Fontwell Avenue,
Eastergate,
West Sussex.
PO203RU
18.06.18

We wish to object to planning application AL/ 50/18/PL which requests variance of Condition 10 imposed on planning application AL/121/16/PL. This is to allow the applicant to live in the house before the access is completed. We do so for the reasons listed below:-

TITLE
PROPOSED
SITE PLAN

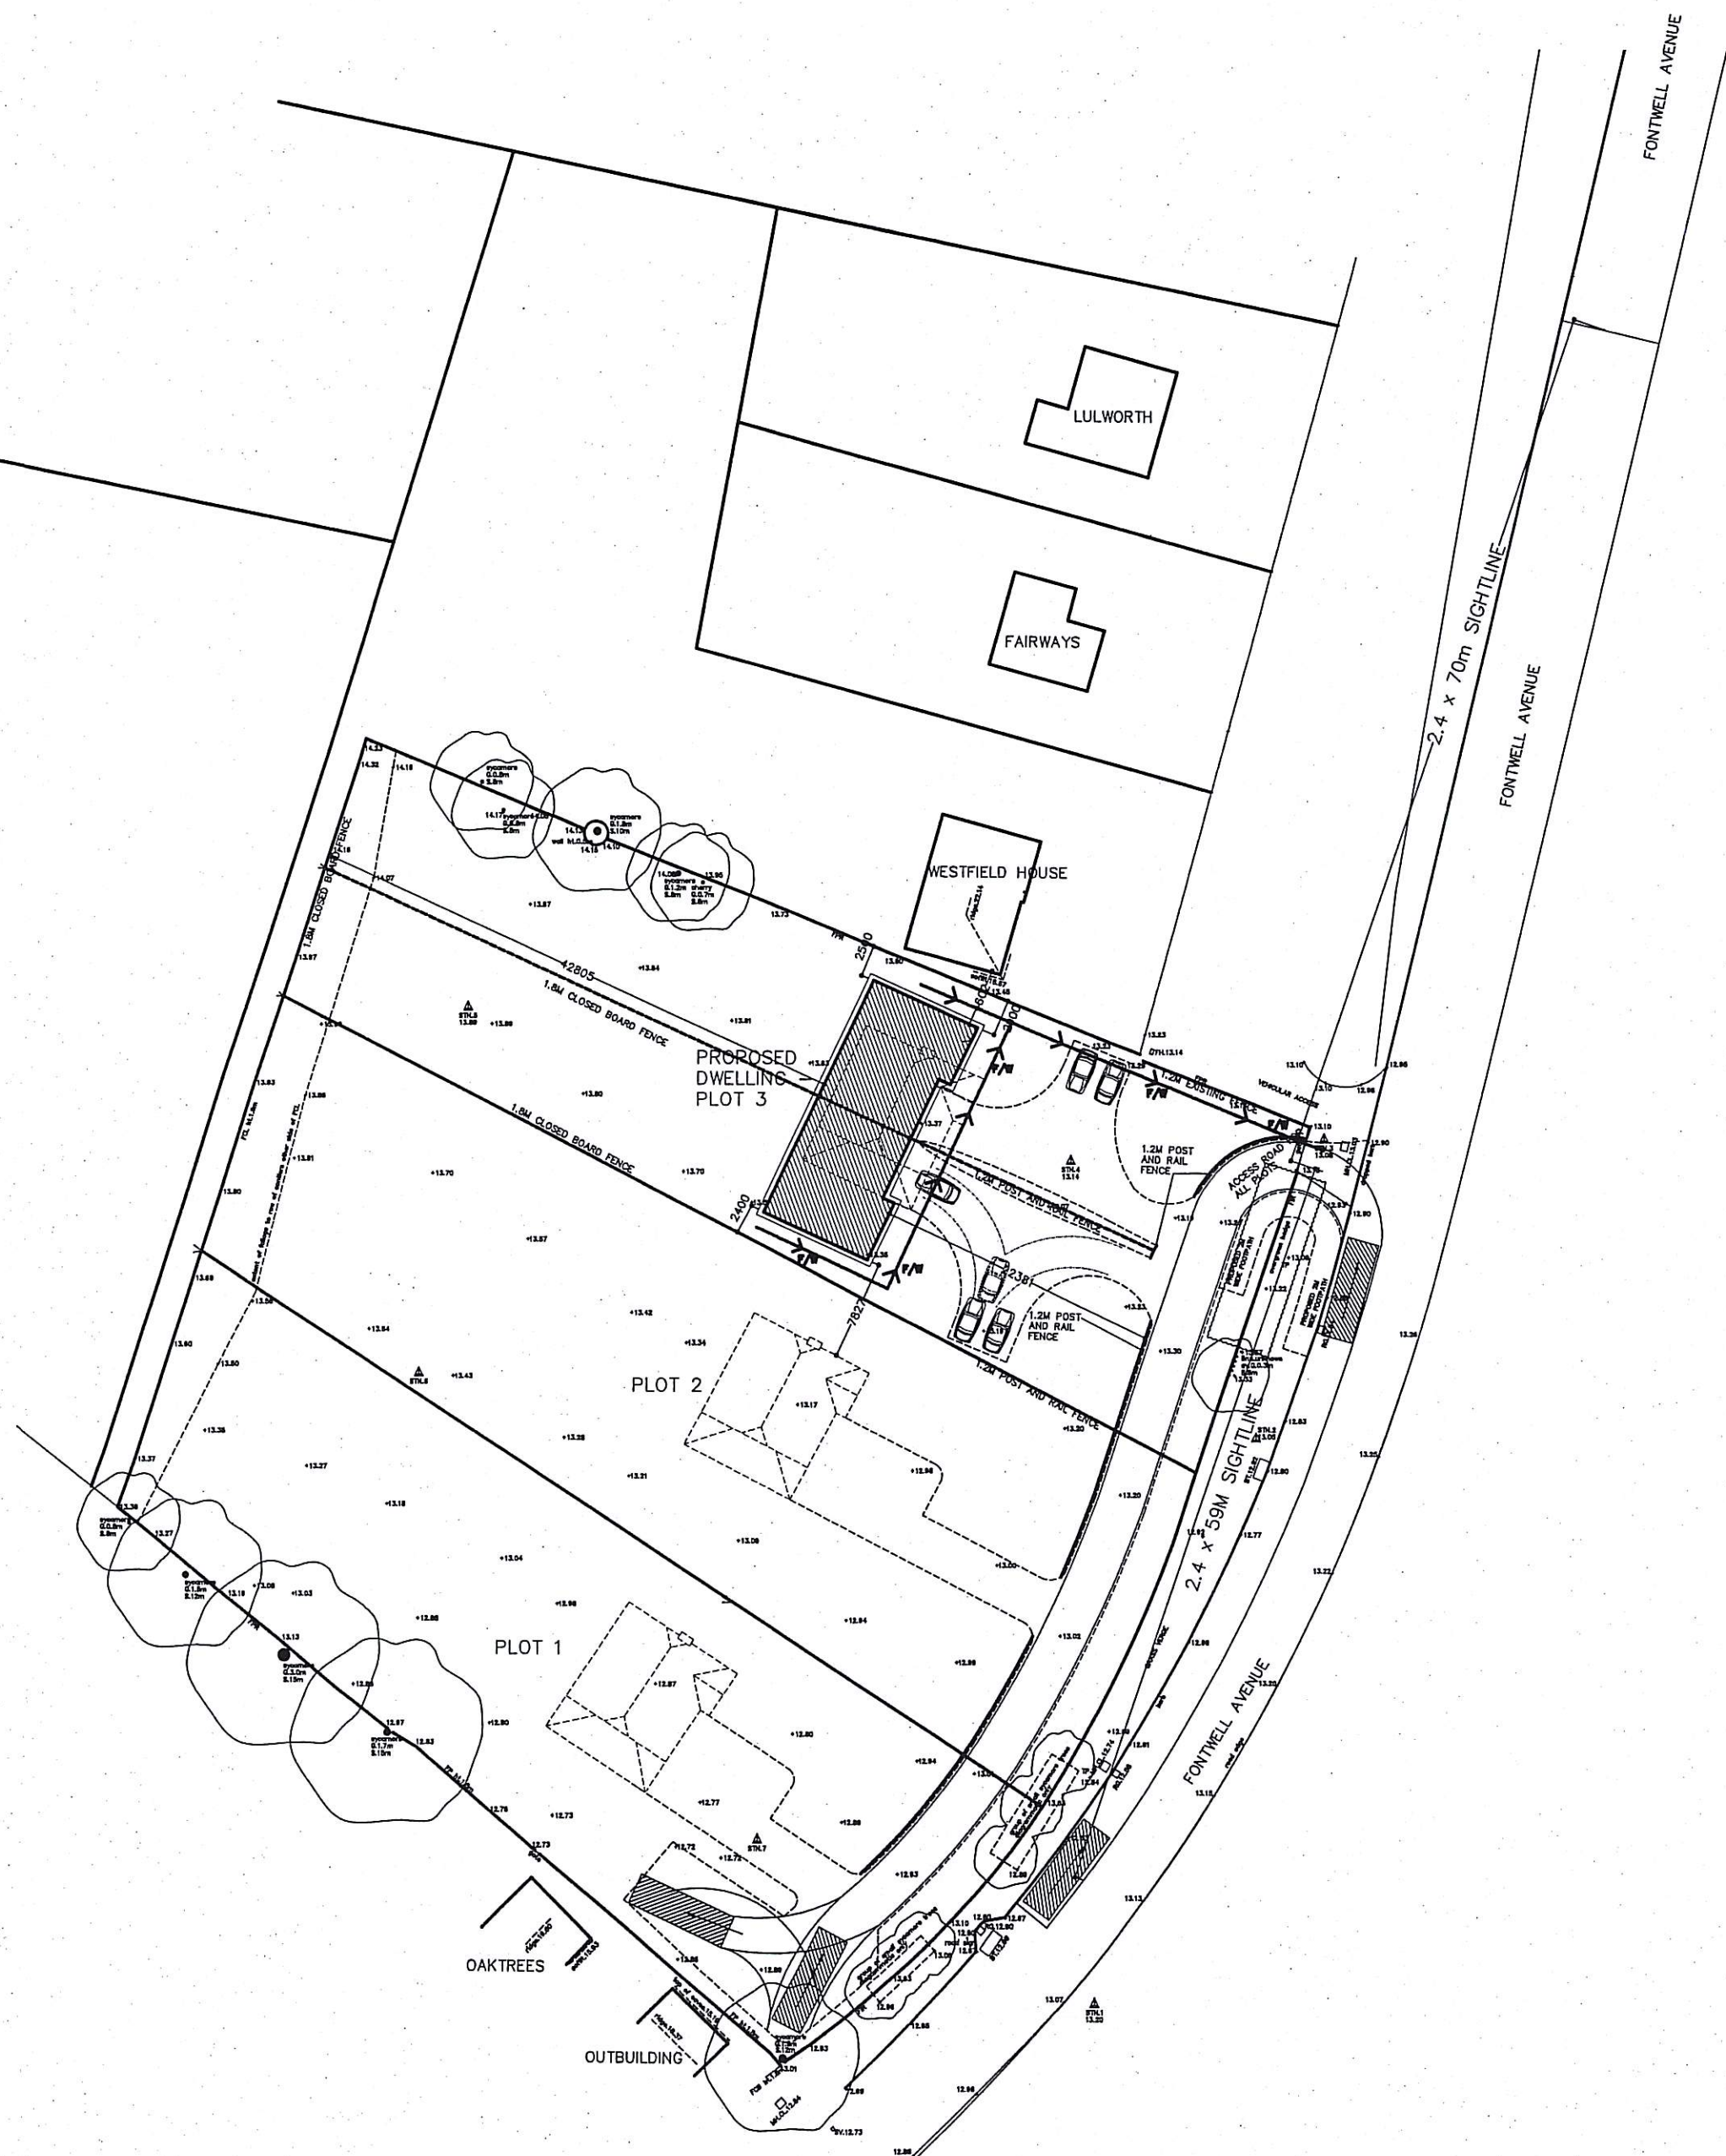
1. The Applicant states in his application that he has completed the access road to the site, as required. This is not the case.
 - (i) The access is too wide. Mrs. Dannatt has already made two site visits and measured this.

- (ii) The road has been constructed in the wrong place on the land. A buffer/landscape feature, has been omitted and for part of the site, the road runs adjacent to the boundary, instead of about 3m away from it. Mrs. Dannatt has already made a site visit and observed this. There is also a covenant on the land which does not allow this.

- (iii) The road has not been constructed with the materials specified on the planning documents. Instead, large pieces of demolition waste have been used. You have photographs to show this and it is present and visible on the site.
